Re: SSD 6471 - Art Gallery Road, Sydney - Art Gallery of NSW Expansion Project - Sydney Modern.

With Regard to: Art Gallery of NSW Expansion Project - Sydney Modern at Art Gallery Road, Sydney

Fig 8.0A – Proposed location of intake and discharge points

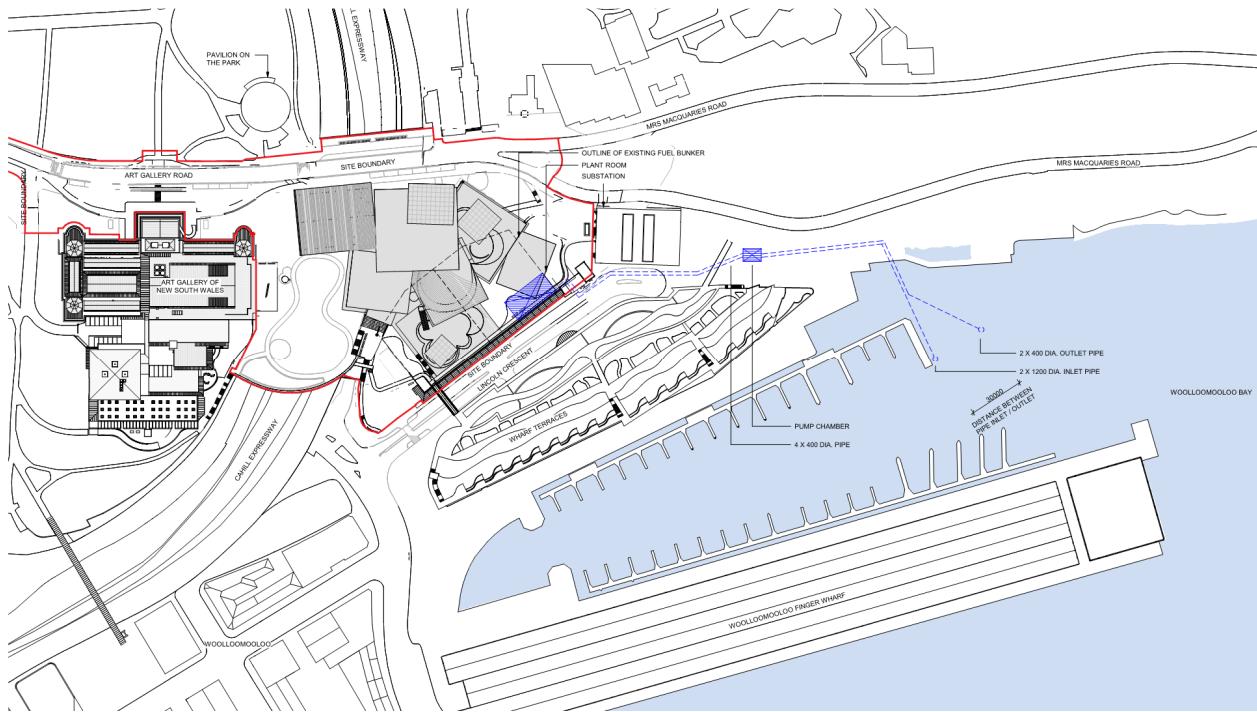
- The exhaust point at the East side of the site adjacent to the zone substation
- The sea water heat exchange system running past the Zone substation

Ausgrid also request further details about the proposed installation of the sea water exchange pipes. These pipes are proposed to cross the South side of the zone substation. There are several Transmission cables which enter the zone substation at this location. These cables may be subjected to derating as a result of any in ground heating sources.
